A National Amenity Society

17th April 2023

Yew Tree Farm adj 63 The Village, Farnley Tyas, HUDDERSFIELD, HD4 6UQ. Application No. 2021/62/93006/E

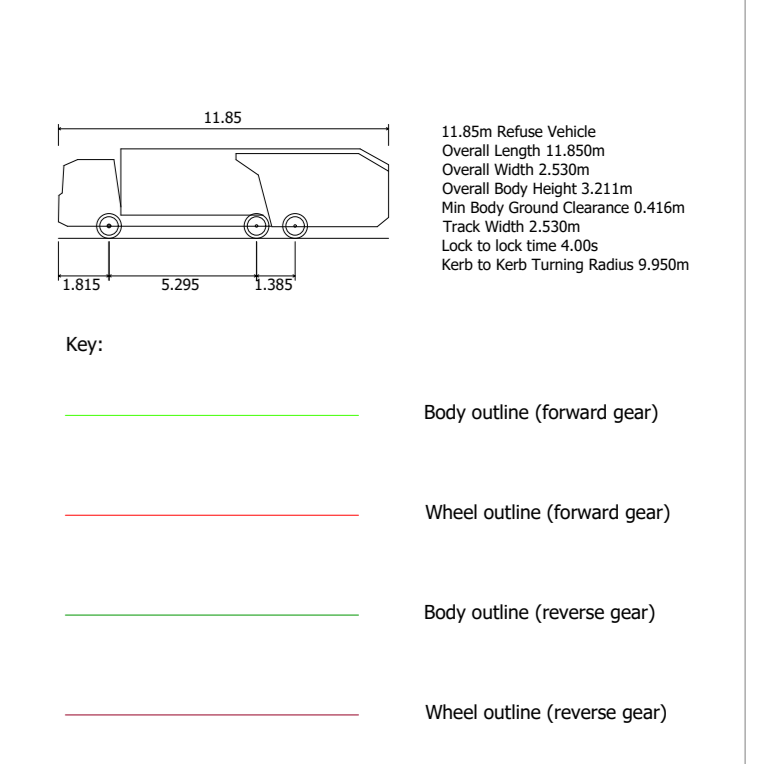
There is clearly scope for developing some new build dwellings to the south of the site. However, the suburban character of the current proposals would appear out of keeping with the historical agricultural context of the site and the rest of the village. As well as architectural considerations, landscaping within the site to provide for private gardens and car parking also needs to be

informed by the existing agricultural character of Yew Tree Farm. The use of the area facing onto the village at the front of the site for car parking would be wholly inappropriate to the setting of the listed buildings and the conservation area. A revised scheme that is better informed by the historic character of the site should better reveal the significance of the conservation area and meet the requirements set out in paragraph 190 of the NPPF.
